Deadline 2 Representation to PINS on Sizewell C

Bill Parker
2nd June 2021

TR544: PRELIMINARY SCDF DESIGN  
NOT PROTECTIVELY MARKED

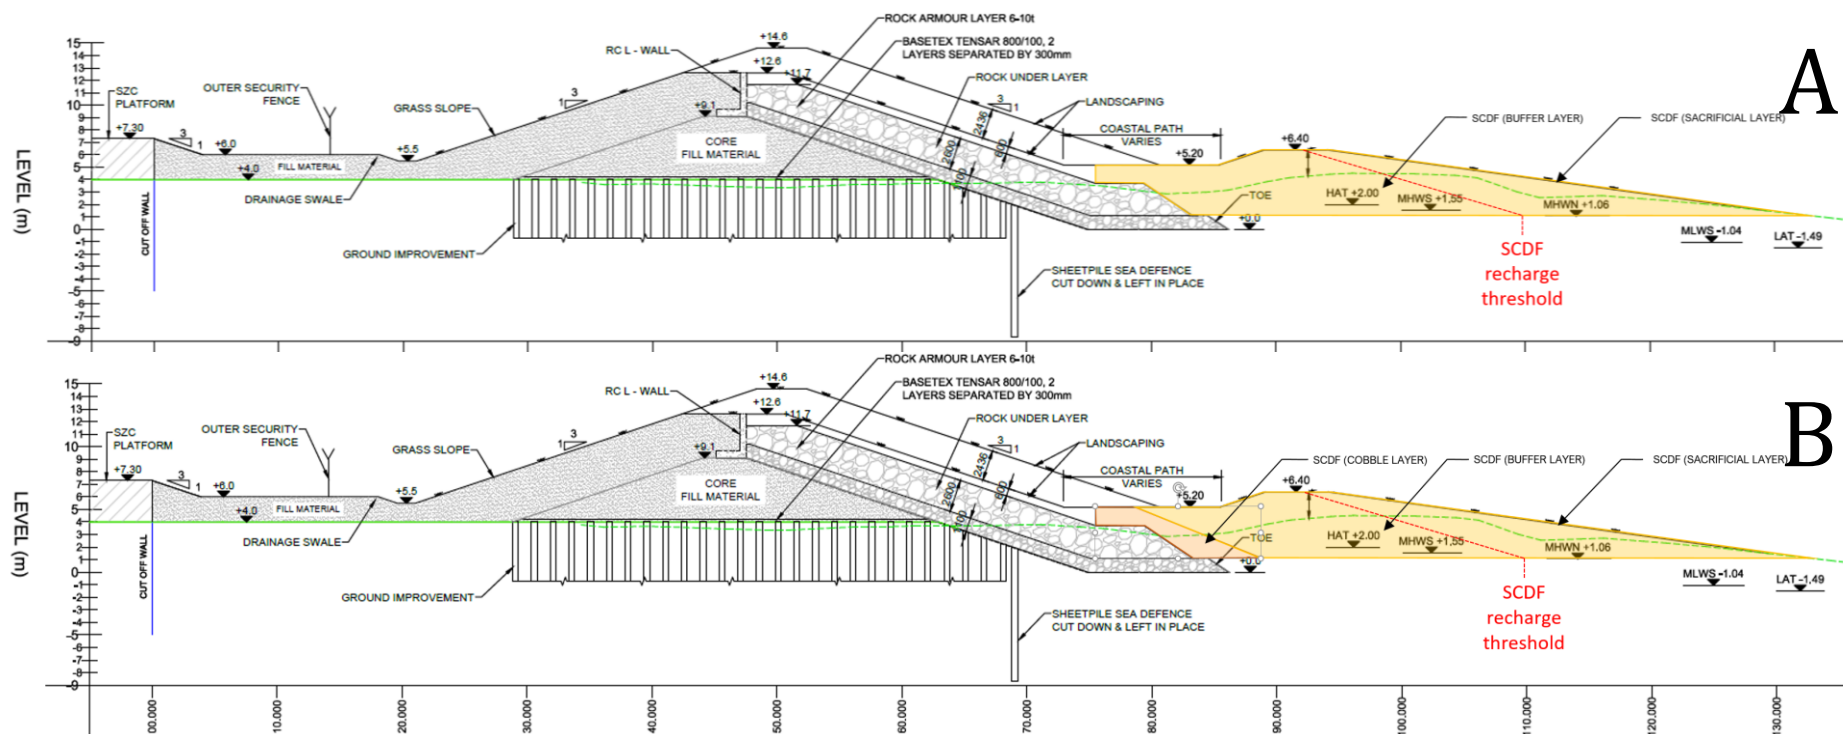
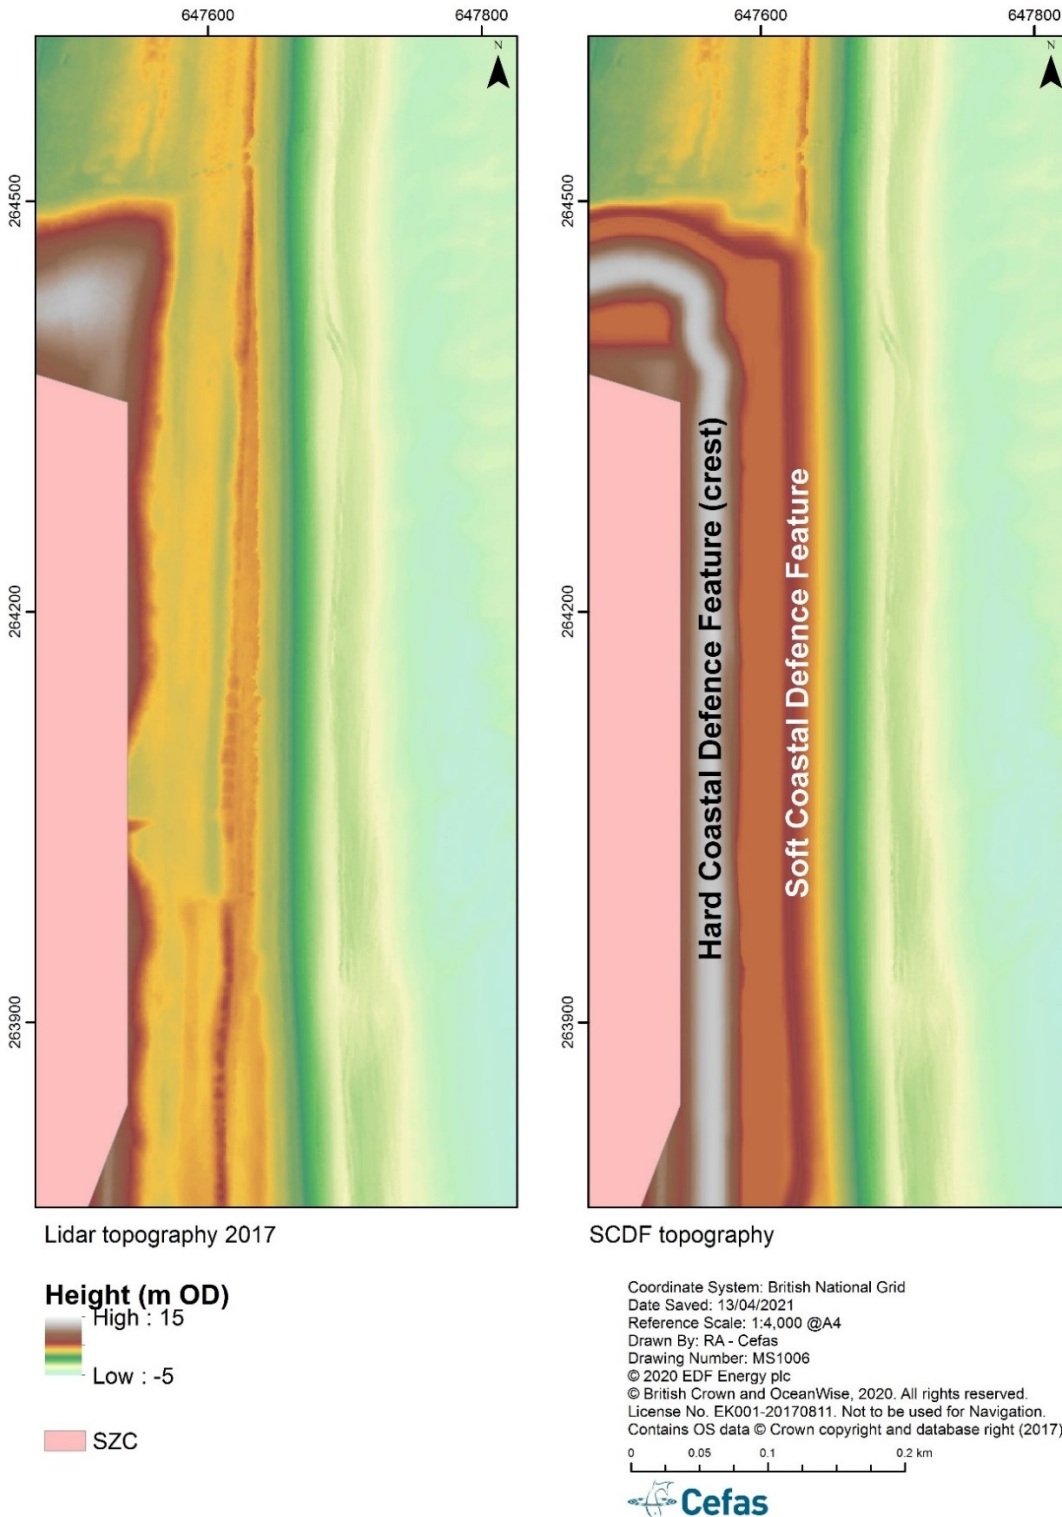
The evidence presented by EDF to-date and the quality of the information on the coast defences has been lamentable, especially as they were available at the beginning of Hinkley Point C DCO

The draft Coastal Monitoring and Mitigation Plan lacks meaning as the detail on the coast defence measures are still not available. The ExA is asked to ensure that the issue of monitoring across a wide spectrum of issues is examined in detail and that meaningful controls are recommended.

DRAWING TITLE:
MAIN DEVELOPMENT SITE SSSI CROSSING
(UNDER CONSTRUCTION - BAILEY BRIDGE STAGE)

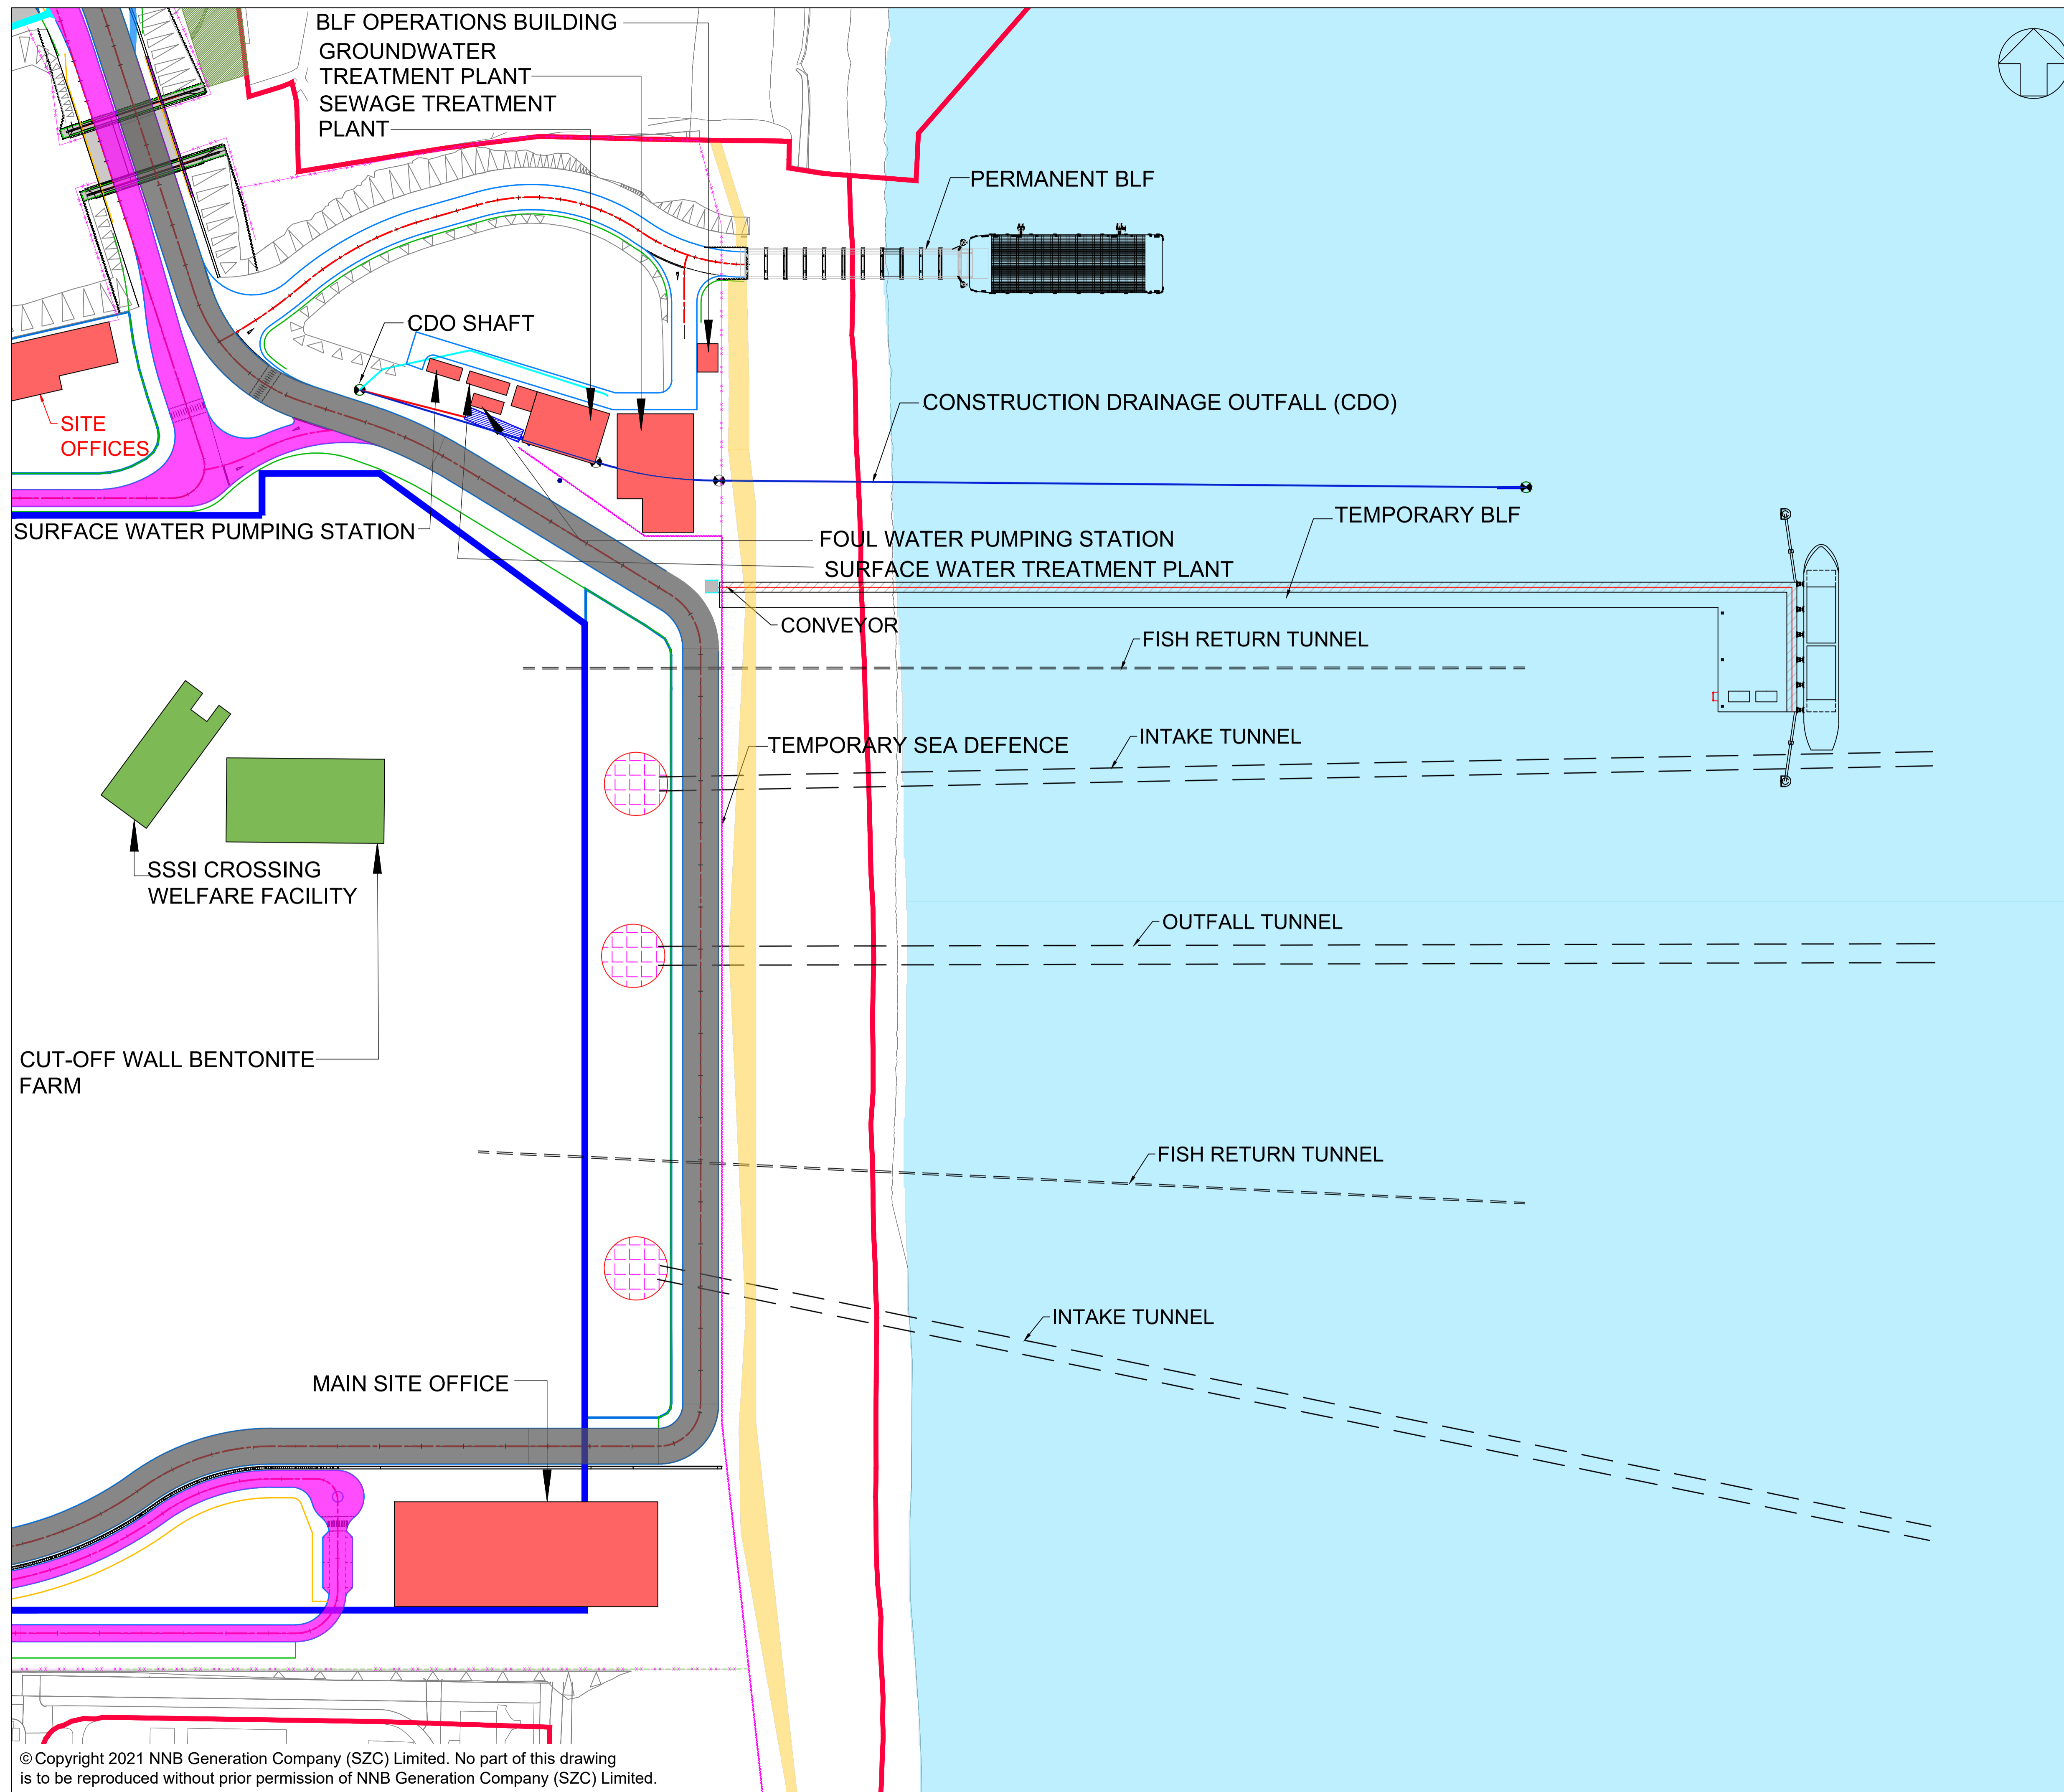
The proposed SSSI crossing is a poor design for the location and the hydrology and environmental impacts have been poorly assessed. The bridge solution which would have less impact on the water levels and flows, reduced impact on species connectivity
